Sea Link

Document 7.4.10: Draft Statement of Common Ground Between National Grid Electricity Transmission and the Maritime and Coastguard Agency.

Planning Inspectorate Reference: EN020026

Version: **CD**
January **March** 2026

Plate 1.1 Cable route overview showing stakeholder areas of concern in relation to water depth

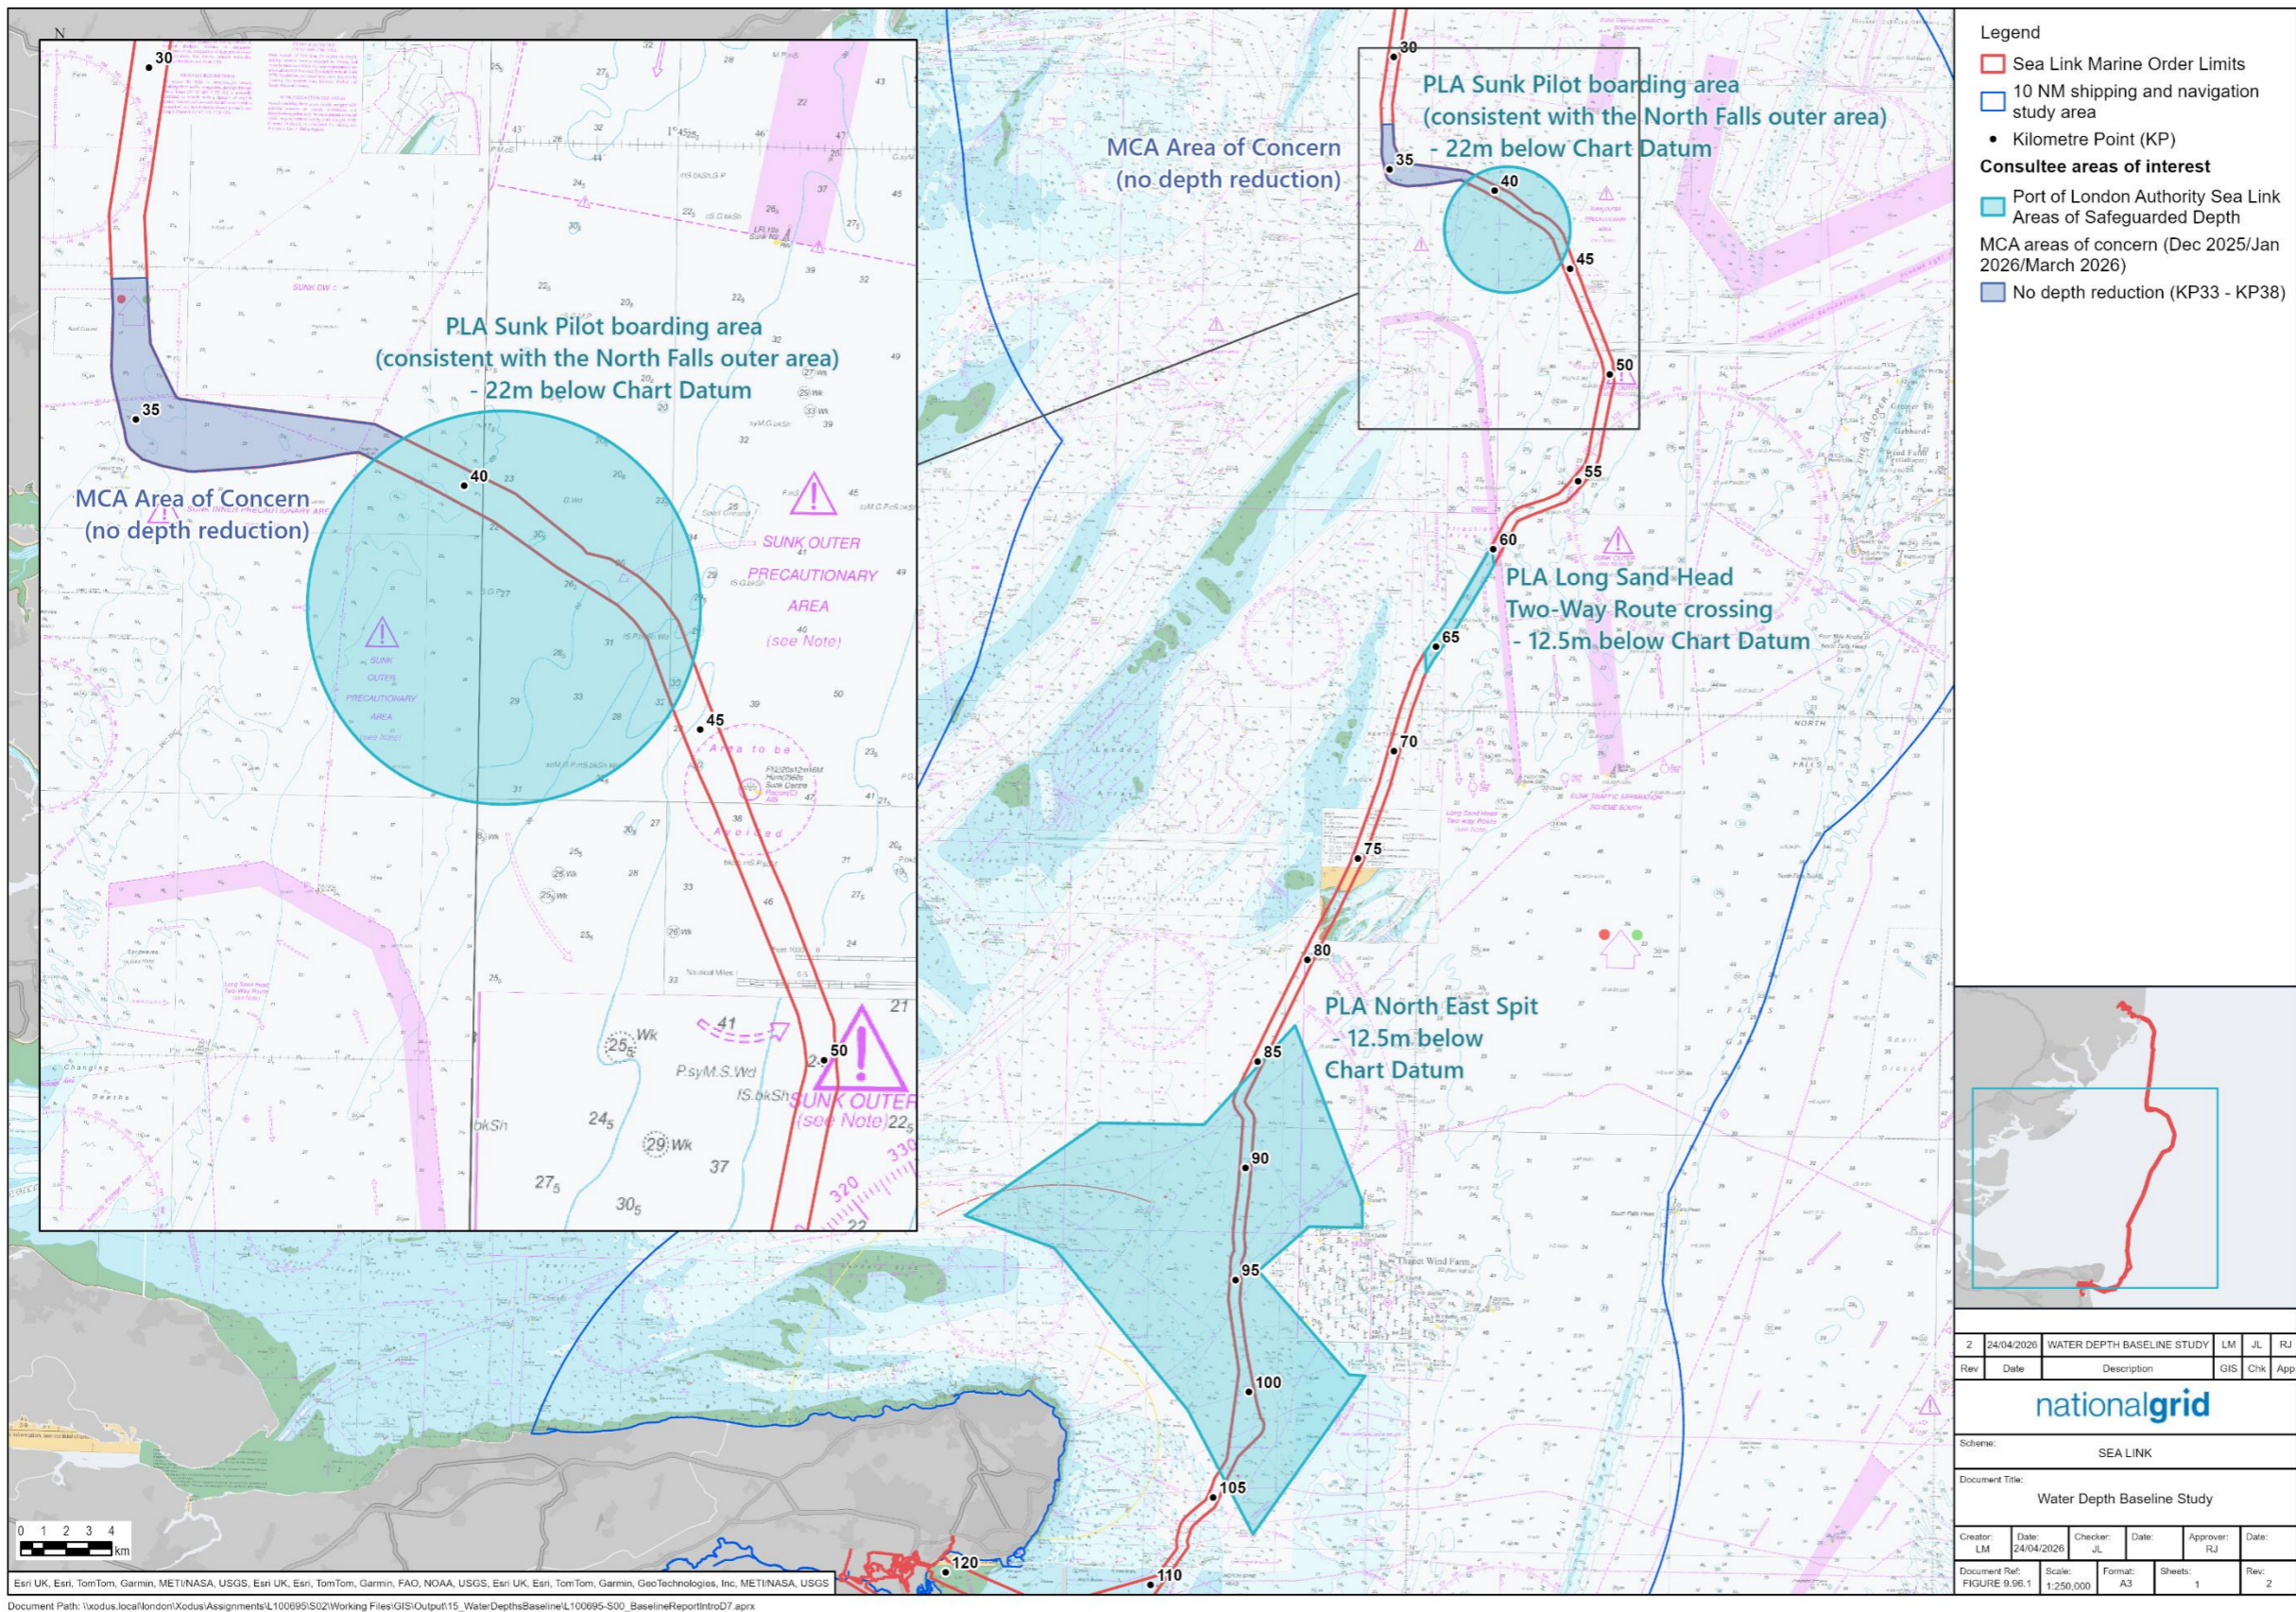
Ref	Relevant Application Document	Summary of Description of Matter	MCA Current Position	The Applicant's Current Position	Status
			<p><u>Long Sand Head and NE Spit.</u> Sea Link is committed to 12.5m depth below chart datum to be maintained within the Long Sand Head (LSH) two-way route and at the Northeast Spit which has been agreed with the ports for their purposes, and the MCA fully supports. We would like to ensure burial in the LSH route (between KP 60 and KP 66) is as per CBRA and apply the 5% maximum depth reduction which is achievable with the water depth at this location. NE Spit (between KP 85 and KP104) where the water depth is less than 12.5m, the 5% reduction may not be appropriate across this area.</p> <p>The 5% maximum depth reduction would therefore only apply outside of those areas where safe guarded depths are agreed / being agreed between the Ports, MCA and the applicant.</p> <p>In addition, at KP 33-38 the MCA would like no depth reduction as per CBRA, due to the proximity of the Deep-Water anchorage.</p>	<p>do so through Examination with the goal of providing clarity, reaching agreement on this matter, and minimising potential impacts. <u>The Applicant confirms that Application Document 9.104 Areas of Safeguarded Water Depth Plan [REP4-098] was submitted at Deadline 4. The Applicant also confirms that Application Document 9.92 (A) Outline Cable Specification and Installation Plan [REP4-090] includes our commitment to not impeding the Areas of Safeguarded Water Depth and has also been submitted at Deadline 4 which is secured within the Deemed Marine Licence (DML) under Condition 4.</u></p> <p><u>Condition 4 of the DML requires the Cable Specification and Installation Plan to be submitted to and approved by the MMO before works can commence. This Plan needs to be in accordance with the outline Plan (which already features the commitment). Once submitted to and approved by the MMO it forms part of the licences activities which are enforced by the existing and comprehensive regulatory regime under the Marine and Coastal Access Act 2009.</u></p> <p><u>In addition to this and following recent discussions with the Port Authorities, the Applicant has also now included a bespoke DCO Requirement in its submission at Deadline 5.</u></p> <p><u>The Applicant confirms that a Post Lay burial survey would be completed post installation. This is currently secured within Application Document 9.92 (A) Outline Cable Specification and Installation Plan [REP4-090] has been submitted at Deadline 4 which is secured within the Deemed Marine Licence (DML) under Condition 4. The Applicant also notes the following feedback received from the MCA at Deadline 4:</u></p> <p><u>It is the MCA's view that the requirement for a post-lay cable burial survey (to confirm the target has been met) is suitably secured in the DCO DML part 2 Schedule 16 Conditions 14, which states:</u></p> <p><u>14. (1) The undertaker must submit to the MMO within three months of completion of licensed activities, an 'as built' plan which will display (a) the location of the cable as laid with specific details of the achieved burial depths, (b) locations of buried and surface-laid cables, (c) the placed location and quantity of rock placement or concrete mattressing used in these licensed activities; and (d) final clearance depths over the protected cables and clumped disused cables.</u></p>

Ref	Relevant Application Document	Summary of Description of Matter	MCA Current Position	The Applicant's Current Position	Status
3.2.8	N/A Application Document 9.12 (B) Outline Navigation and Installation Plan [REP4-076]	New MCA Areas of Interest, Dec 2025	refining communications between the three developments to ensure a coordinated approach.	The Consultee has sent the Applicant four additional areas of interest, as follows:	Under discussion
			<p>The Consultee has provided the applicant with MCA's area of interest (AOI) for safeguarded 22m water depth, and the AOI for concurrent RAM and Restricted Visibility Stop Ops.</p>	<ol style="list-style-type: none"> 1. An extended area of safeguarded depth to 22 m (with 0.5 m over-dredge) in the Sunk Pilot Boarding area, extending between KP 33 to KP 45. This is to include areas closer to the Sunk Deep Water Anchorage as well. 2. An extended area of avoiding concurrent RAM activities, from between KP 35 to Sunk Centre, to avoid SIMOPS with Five Estuaries and North Falls within the SUNK Outer Precautionary area where cable crossings are expected. 3. The Restricted Visibility Stop Operation should be applied to the entire Sunk area KP 33 to KP 50. 4. The MCA disagrees with the PLA and states that they believe 12.5 m safeguarding is not sufficient for the "Long Sand Head Two-Way Route Crossing area". The MCA establish an extended area including and beyond the Long Sand Head Two-Way Route Crossing area, within which the MCA will need more information and further consultation if there is <u>any</u> depth reduction, between KP 45 to KP85.

<p>The MCA's position remains as per written response and as presented at the meeting on 16 January 2026. No activities involving vessels Restricted in Ability to Manoeuvre (RAM) should run concurrently with activities involving RAM vessels planned by the Five Estuaries and North Falls project developers from KP 33 – KP 50 (as per box on image below). And no project vessels with Restricted Ability to Manoeuvre (RAM) (cable laying, UXO clearance, survey etc) are to operate in the wider Sunk area when visibility is below nautical 2 miles.</p>		
			<p>The MCA has clarified this to the project team on 2nd March that at KP 33-38 there should be no depth reduction as per CBRA due to the proximity of the Deep Water anchorage, and at KP38-KP44 the ports' 22m requirement applies. The 5% applies to the whole cable route outside of any agreed safe guarded depths, whichever provides maximum depth. There is no conflict therefore with the port's requirements.</p>	<p>The Applicant is seeking sought further clarity from the MCA on these new areas, which are were substantially larger and more restrictive in their requirements than those which the Applicant and ports stakeholders have been collaborating on, and on which the Applicant and ports stakeholders have previously reached agreement. The Applicant will discuss discussed this matter at a meeting with the MCA arranged on 16 January 2026.</p>

<p>The Applicant confirms that following the meeting on the 16 January 2026, clarity was provided from the MCA with regards to their Areas of Interest. The Consultee would like the 5% maximum depth reduction to apply outside of the port's 22m safeguarded depth at the Sunk. The Applicant confirms that this is currently secured as Condition 4(6) within the Deemed Marine Licence and is applicable to the whole Offshore Scheme and not just the Areas of Interest identified by the MCA.</p>
